Town & Country Planning Act 1990 (as amended)
Town and Country Planning (Development Management Procedure) (England) Order 2015
Approval of matters reserved by condition imposed under BE/18/17/PL relating to conditions 4-archaeological works, 5-surface water drainage, 9-landscape scheme, 10-protection of existing trees/bushes/shrubs, 14-foul drainage, 15-ecological enhancement scheme, 17-landscape management plan, 18-details of laying out timetable for provisions & future maintenance of Public Open spaces, 20-10% decentralised & renewable or low carbon energy sources, 21-street lighting scheme, 23-vehicle access, 25-car parking spaces, 27-construction of road(s), footways & casual parking areas & 28-Travel Plan statement.
Land West of New Barn Lane Bersted,,

Arun District Council have decided to **REFUSE details reserved by condition for the following reasons:**

The application to discharge Condition 5 imposed under reference BE/18/17/PL is refused by virtue of insufficient detail. The following detail is absent from the submission and should be incorporated as part of any future application to discharge this condition:

LARGE GENERAL PURPOSE HEADWALL

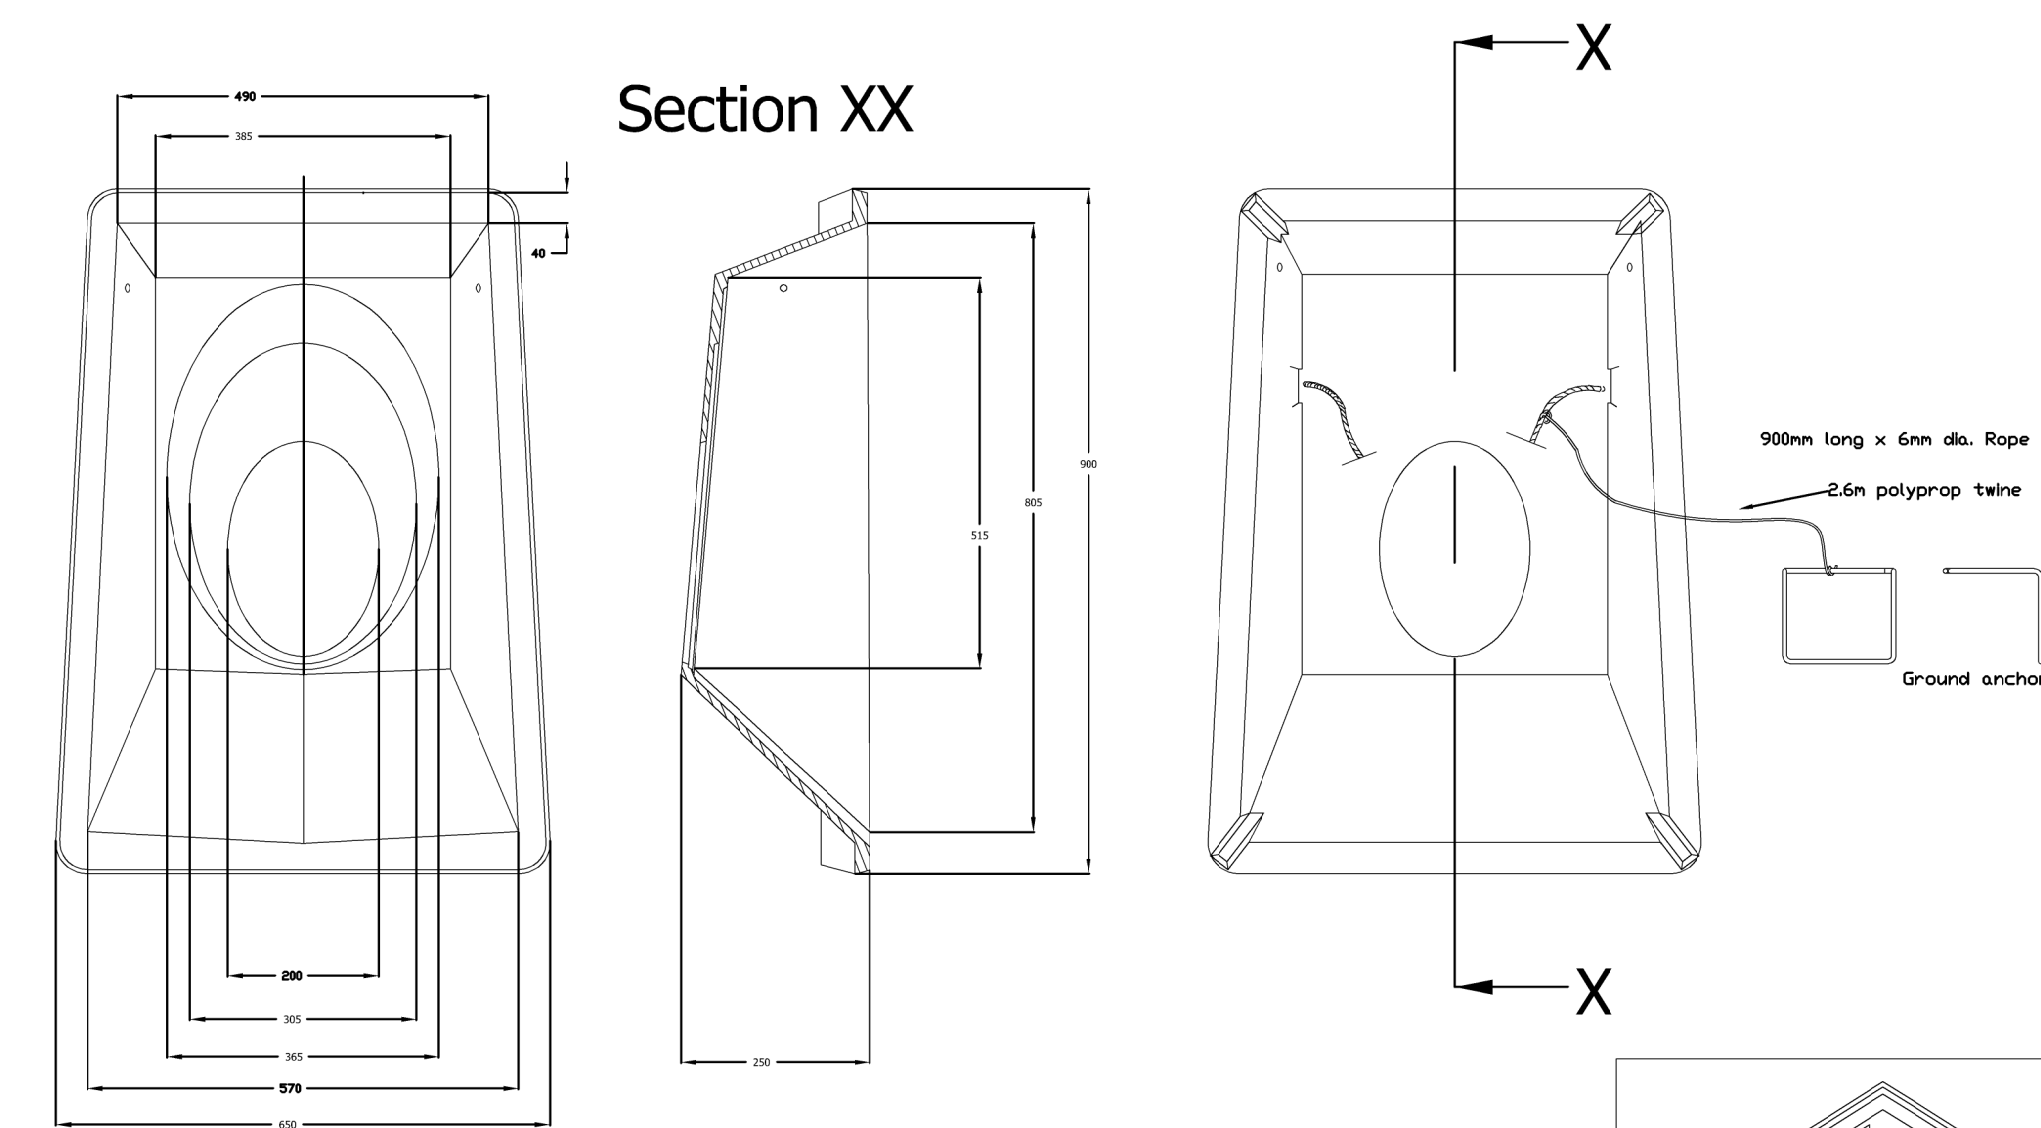
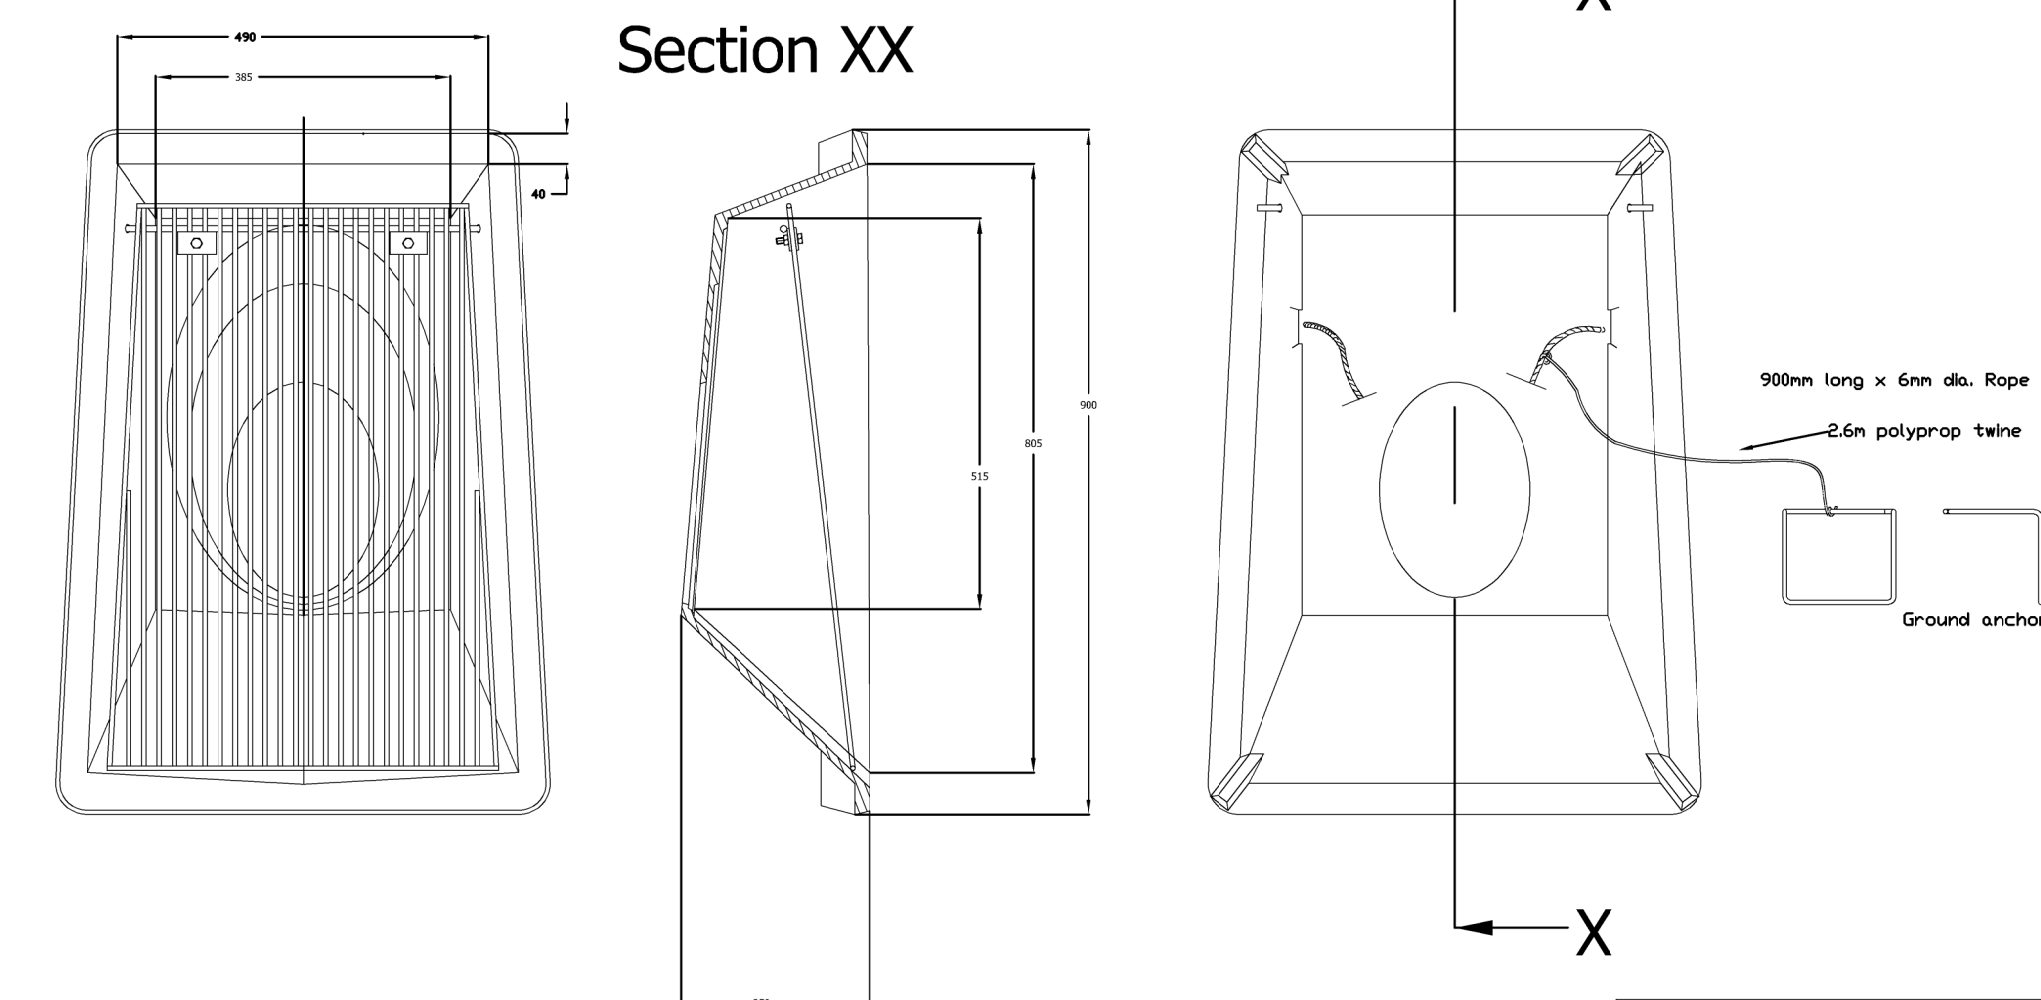
- Low flow channel construction details have not been provided.
- Headwall details do not specify if cranked.
- No Microdrainage calculations for pipe networks have been provided. This should include details for both catchments and 1 in 100 year + 40% simulations for these networks.

- Headwall details have been provided, however since this time it has become apparent that water voles are present within the ditch. Additional information is required establishing the methodology that demonstrates how these works will be carried out without damaging water voles and their habitat. Piped invert levels must be set 300mm above the bed level of the ditch.
